23/10/24

Re: Objection Letter. 2024/91834

Drawing Title
 SWEEP PATH ANALYSIS USING A
 4.845M ESTATE CAR

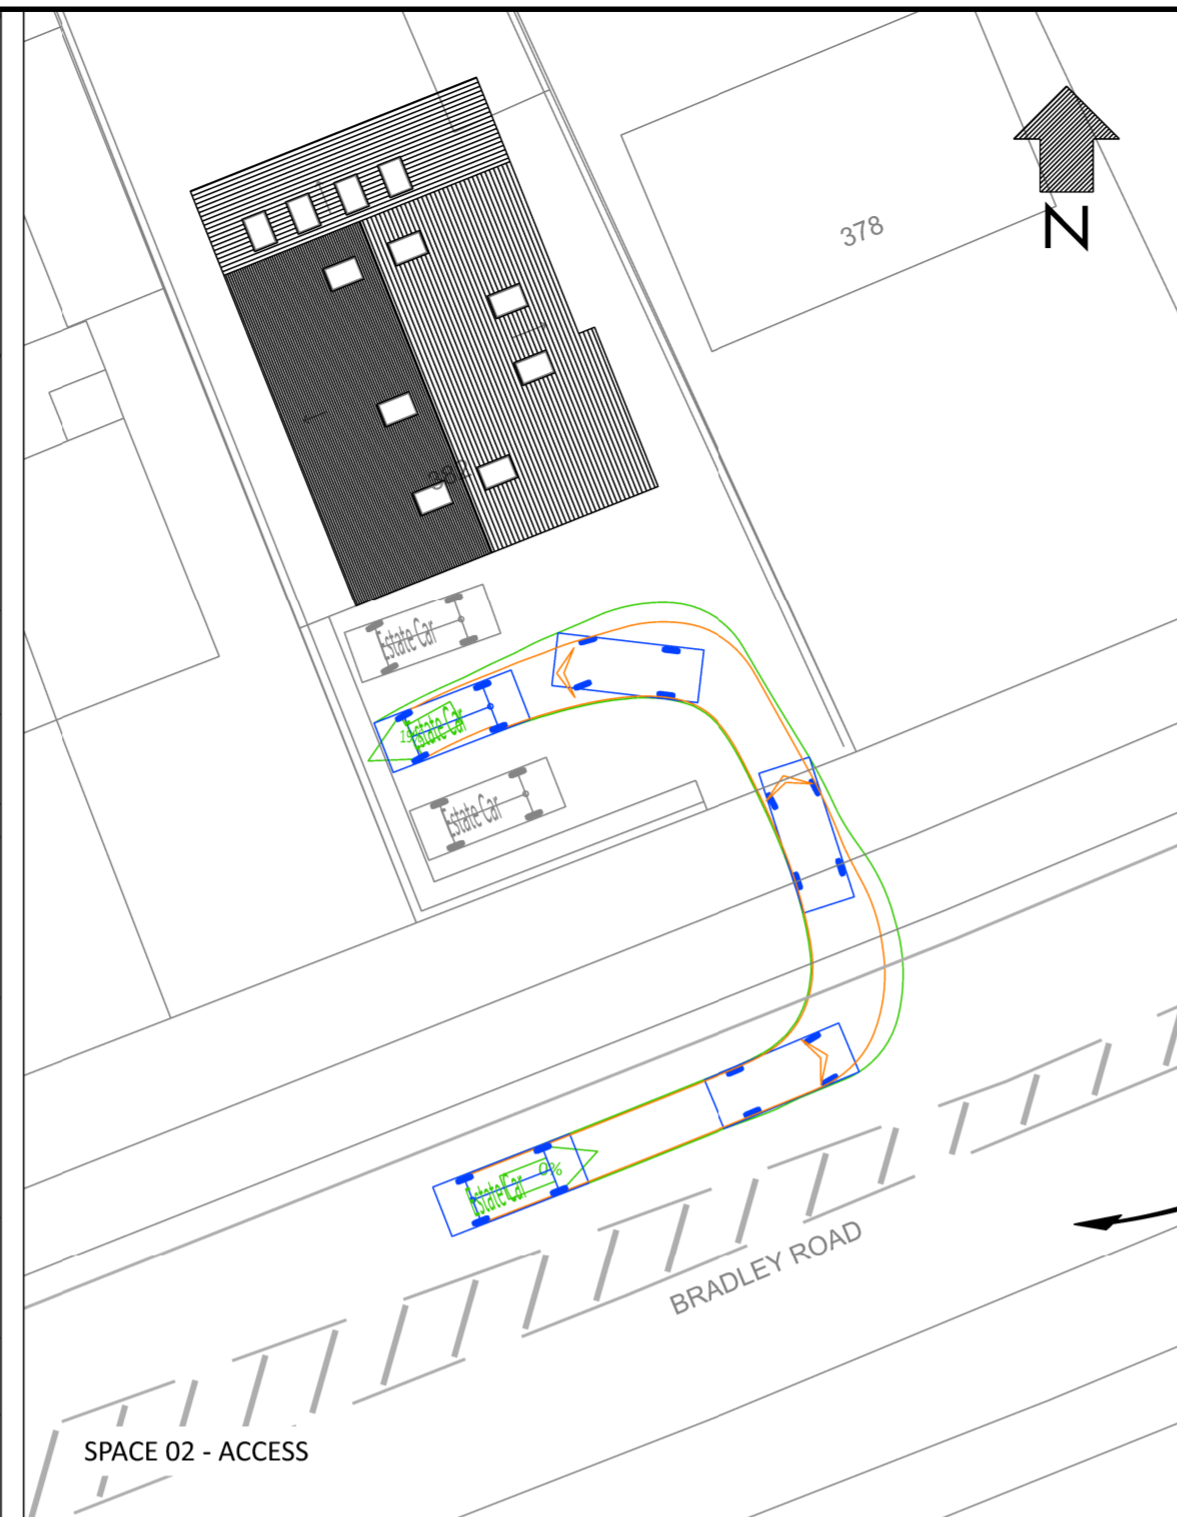
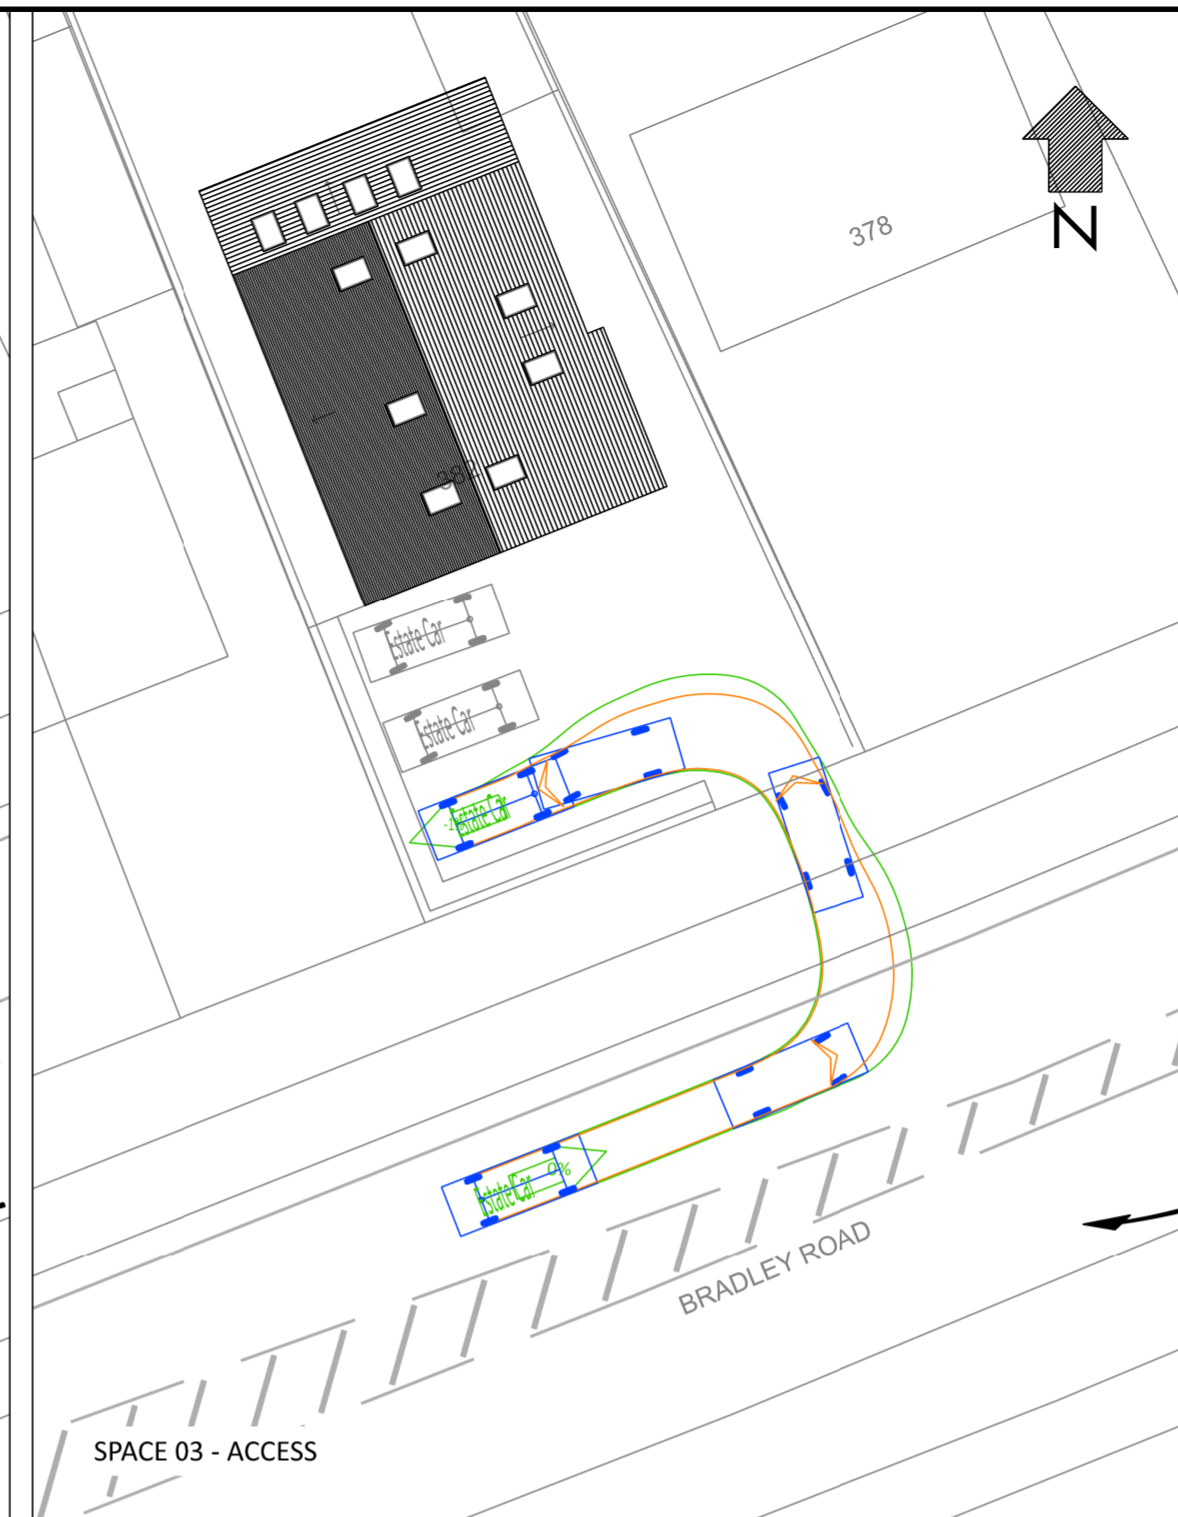
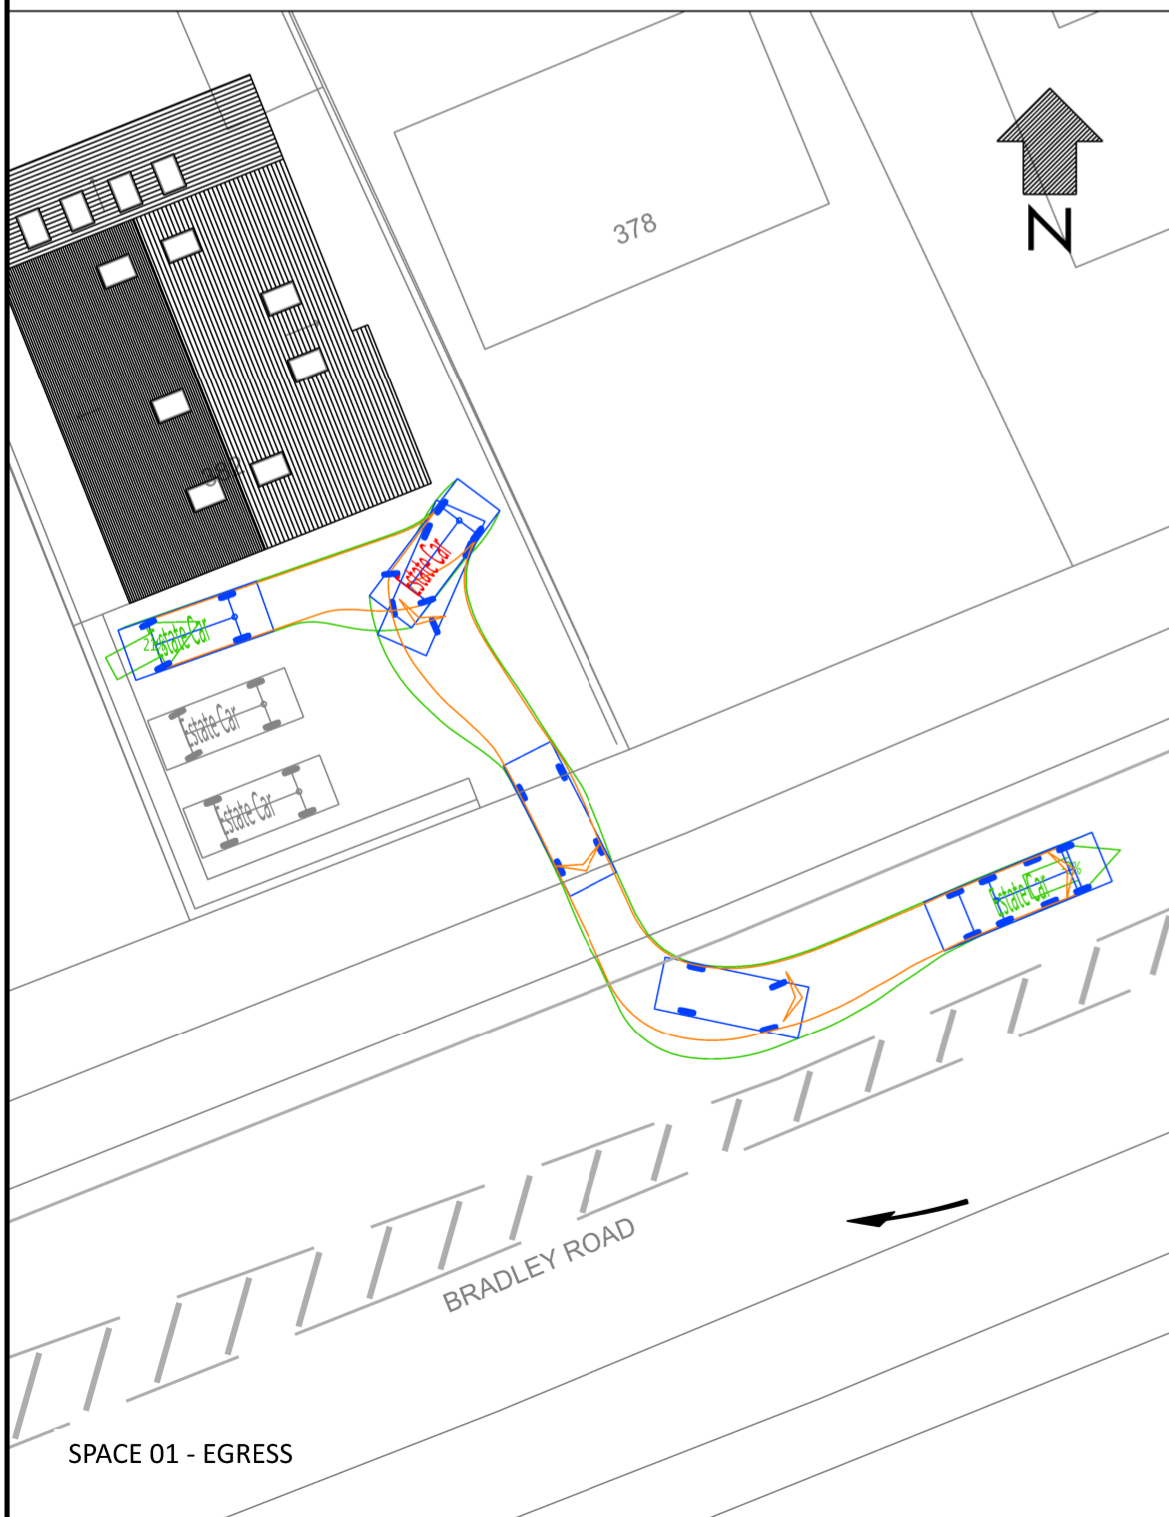
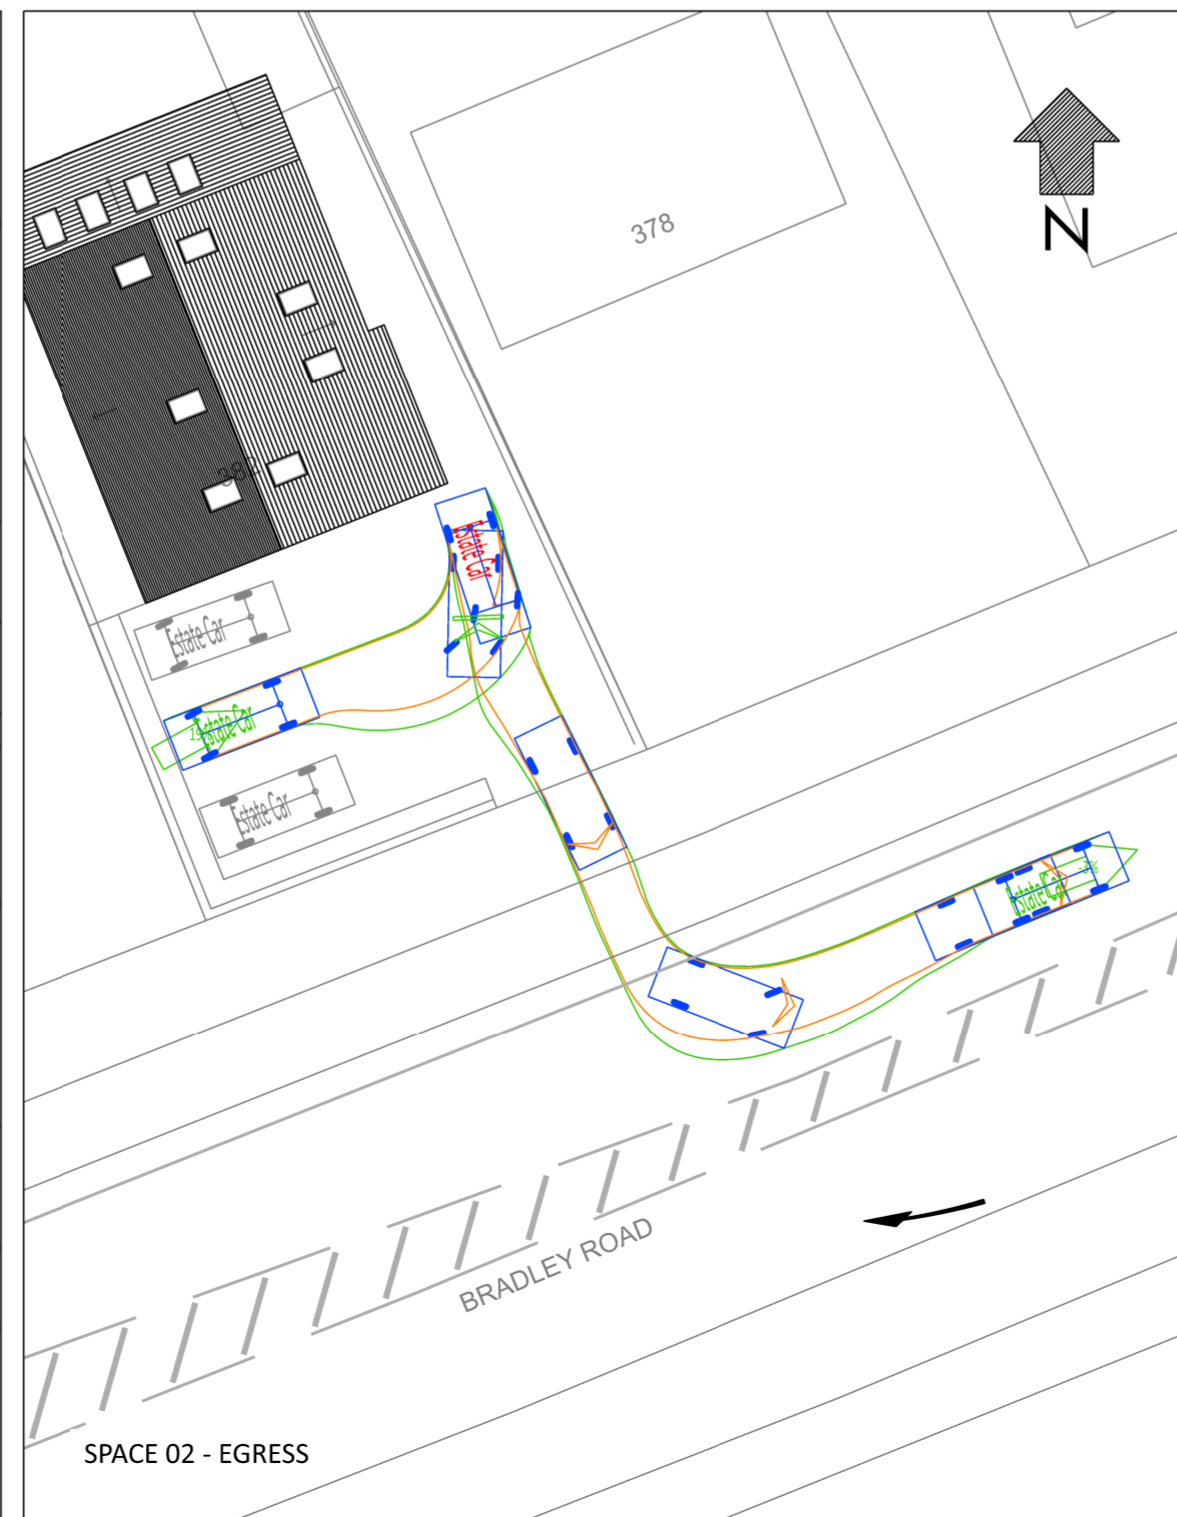
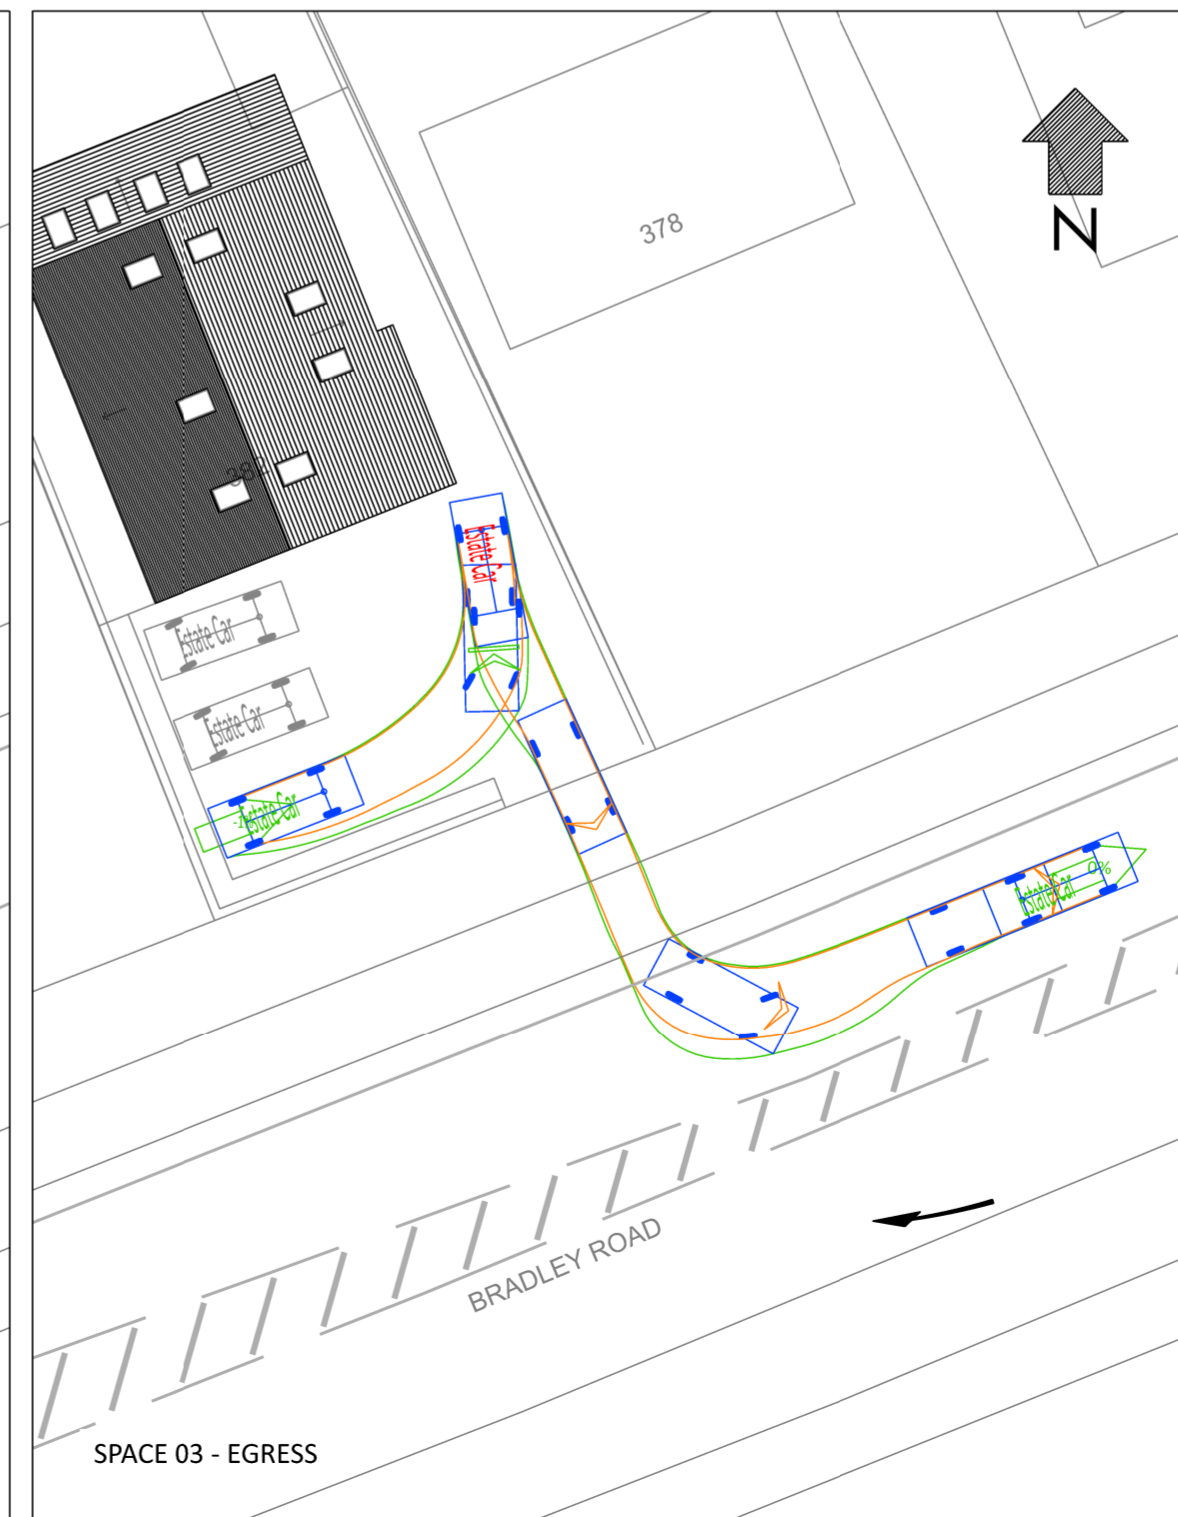
Again.... The mock up of the 3-car diagram is similar to my daughter's primary school work with tracks and prints. We can't be that naive to think a colossal house will only have only 3 cars outside. If passed I will be regularly observing dangerous actions with cars reversing onto the main road. Again, this sketch does not demonstrate that the application site can be accessed effectively and safely by all users.

*****Showing a diagram and traffic flow chart of just 3 vehicles is not representative of a realistic simulation for a house of this size*****
